Epping to Thornleigh Third Track Proposal. Application number SSI 5132.

I/we object to the Epping to Thornleigh Third Track Proposal and consider that the EIS is inadequate and does not address the full impact of this proposal. It will cause untold damage to the health of residents and to the fabric of the Beecroft Cheltenham Heritage Conservation Area. Do not approve this project, reconsider the alternatives and protect the community.

Figure S.6 Cross-section and elevation - New Cheltenham Station concourse building (see also S.5 for artist's impression)

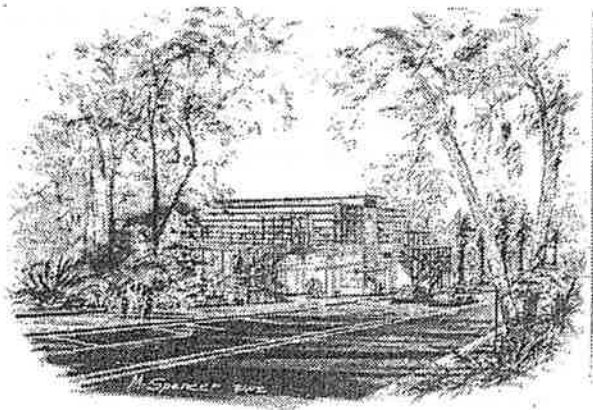
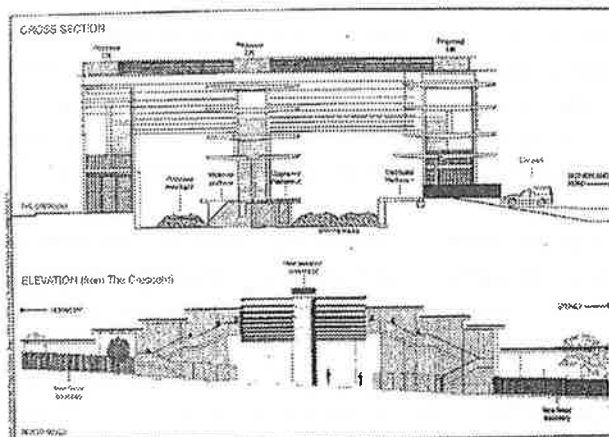
- The proposed redevelopment of Cheltenham Station shows no regard for the HCA. The visual impact of the proposed 13m high glass and steel concourse is totally unacceptable in this HCA.

Figure 5.3 Future Cheltenham Station layout

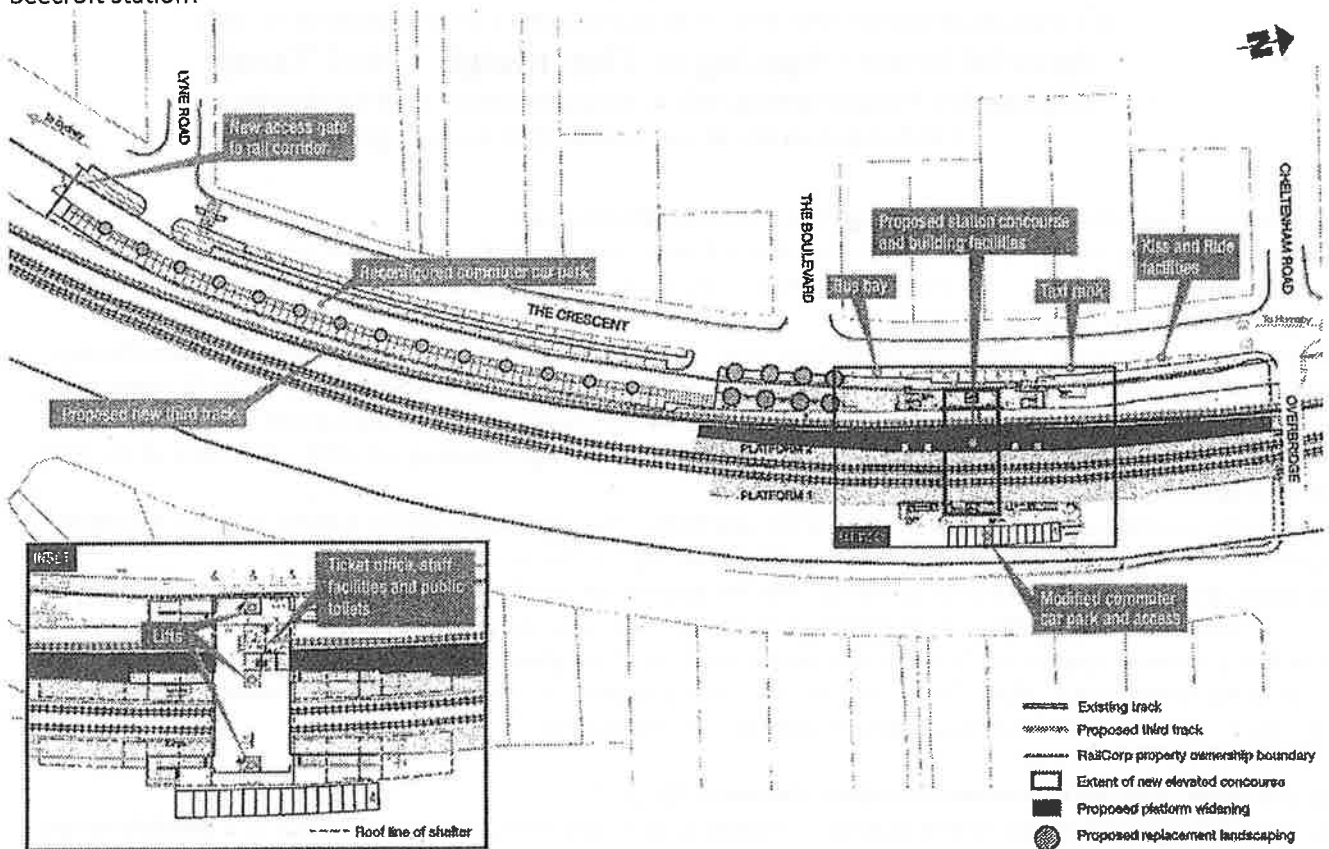
- There has been inadequate assessment of the project's impact on the fabric of the Beecroft Cheltenham Heritage Conservation Area (HCA).
- The plan given for Beecroft Railway station Precinct is vague. The relationship to the trees, playground and original 1895 platform located south of the present station is not shown. A fourth track is shown on the eastern side. The plan does not include urgently needed lifts to allow disabled access at Beecroft Station.
